Tel: 01903 737756
Email: planning@arun.gov.uk
www.arun.gov.uk/planning
Please ask for: Mrs D Johnson
Email: daun.johnson@arun.gov.uk
Telephone: 01903 737762
Our Ref: R/212/25/CLP
Your Ref:
Date: 1st December 2025

Lawful Development Certificate for a Proposed Use or Development

Development: Lawful development certificate for a proposed single storey rear extension and blocking up of window on ground floor.
Location: Aspen House Hurst Road East Preston BN16 3AP

Drawing Name
 Elevations - Proposed

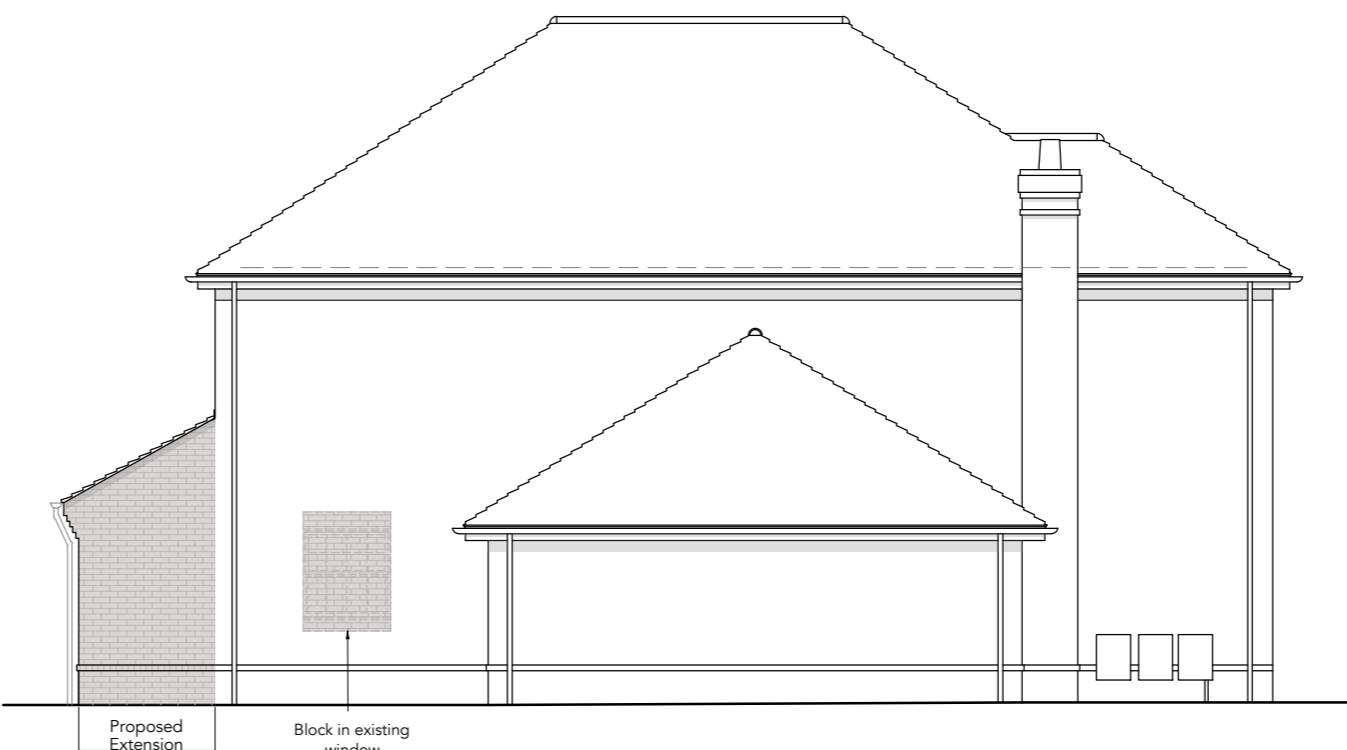
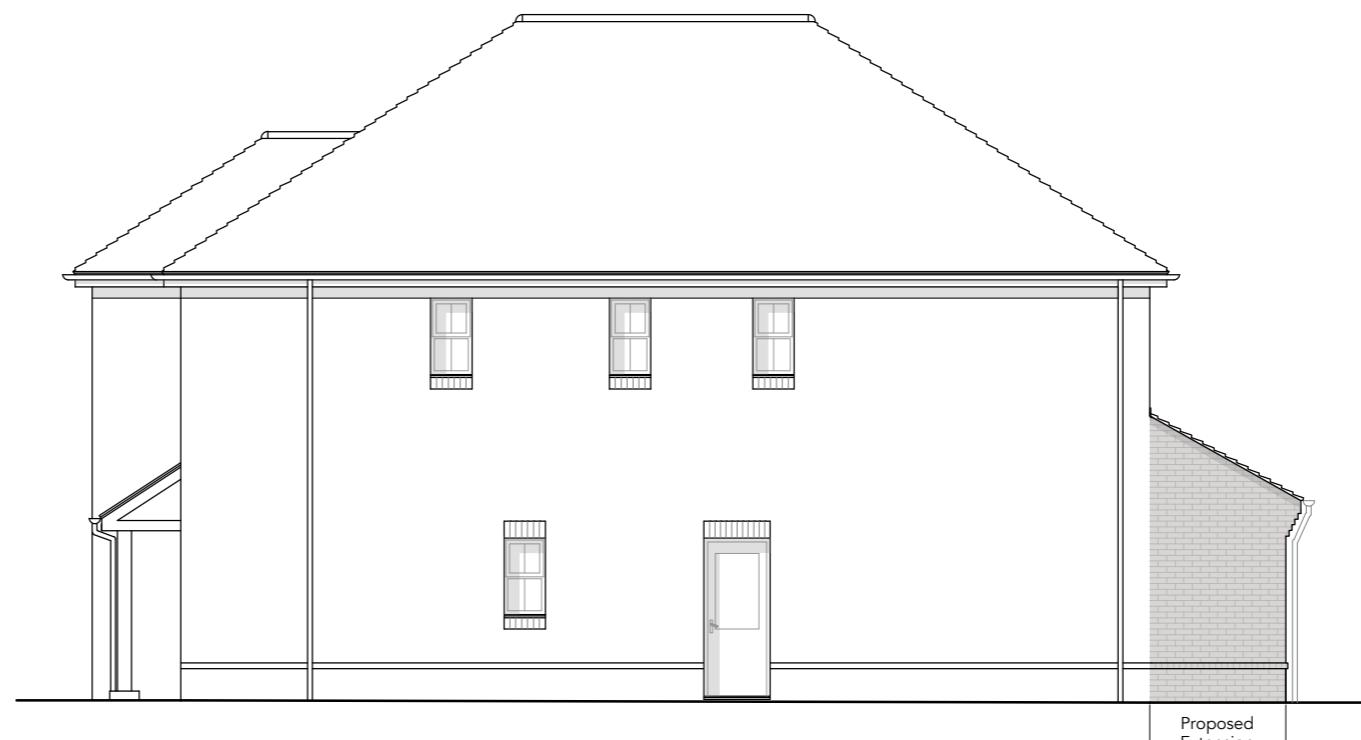
The proposed ground floor plan and east elevations do not accord. Please amend accordingly.
